CITY OF ALBUQUERQUE

**RE: Legacy NAA Apartments-Building 17
6301 Alameda
Requested for Permanent C. O. – Not Accepted
Engineers Stamp Date 9/15/16 (C18D064B)
Certification dated: 11-18-19**

Based on the certification provided in your submittal received 11/19/2019, the above referenced site cannot be accepted for release of Certificate of Occupancy by Hydrology until the following comments are addressed:

GRADING AND DRAINAGE PLAN

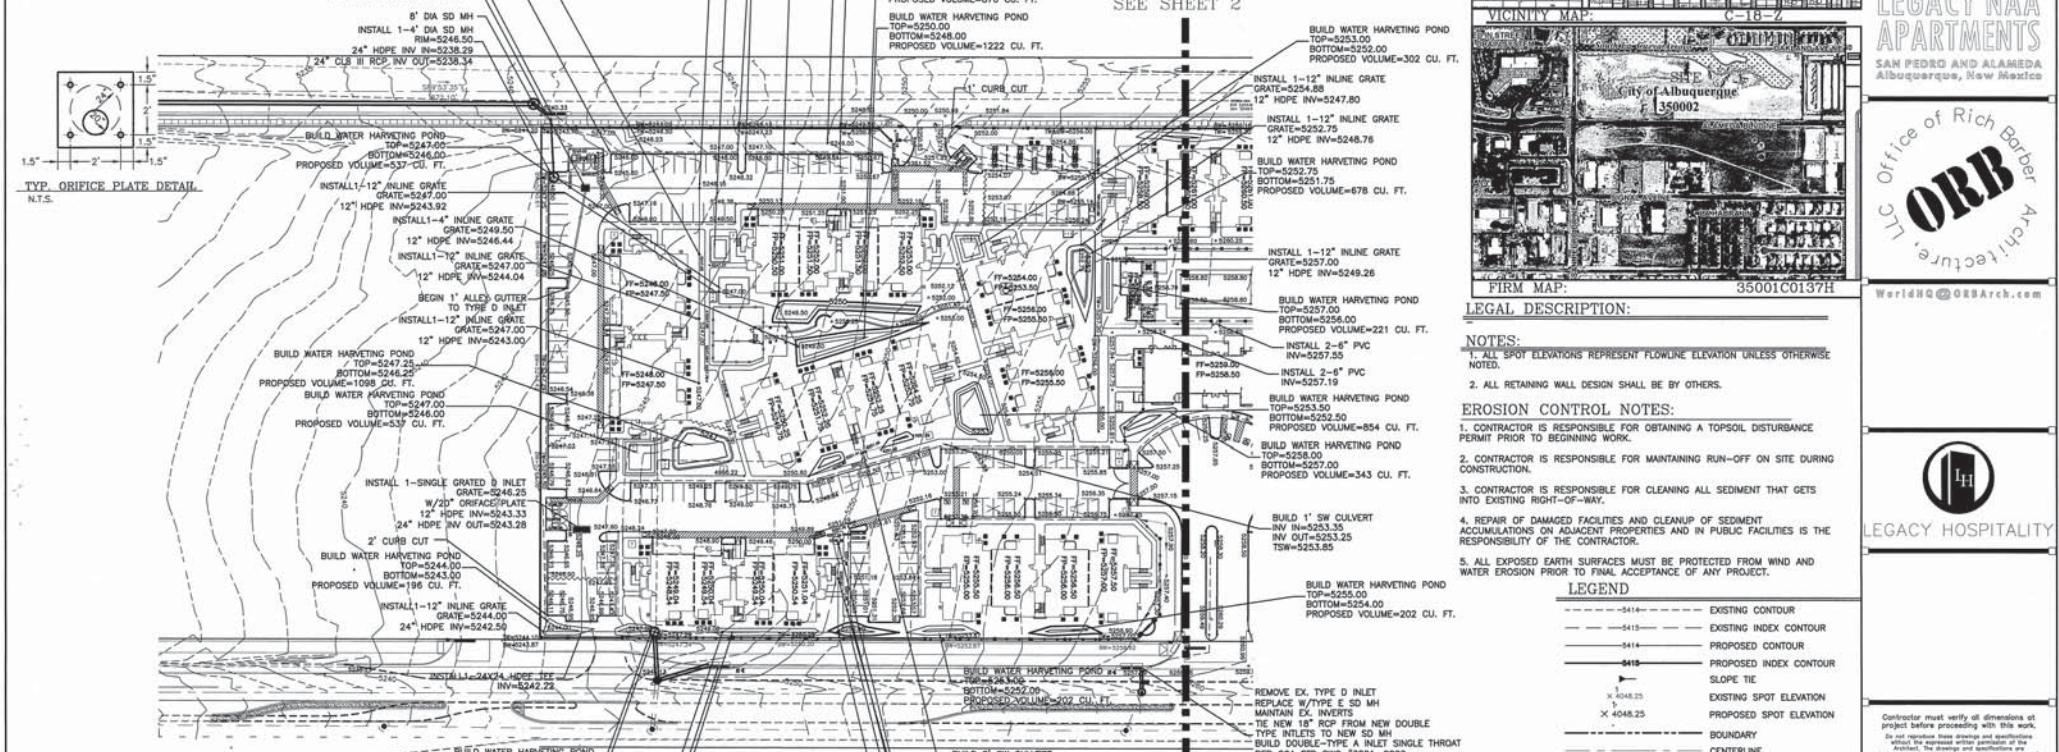
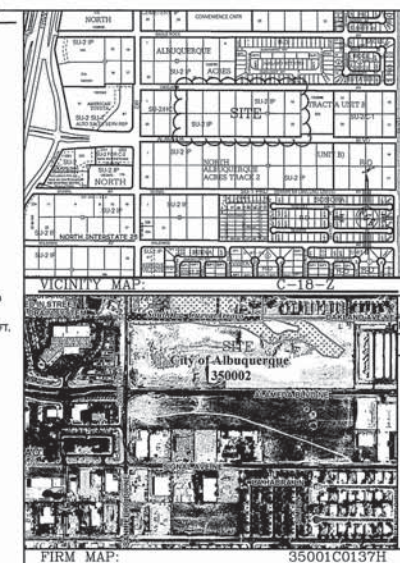
- Water quality pond west of pool house is missing.
- Two 6" PVC pipes missing under sidewalk south end of pool.
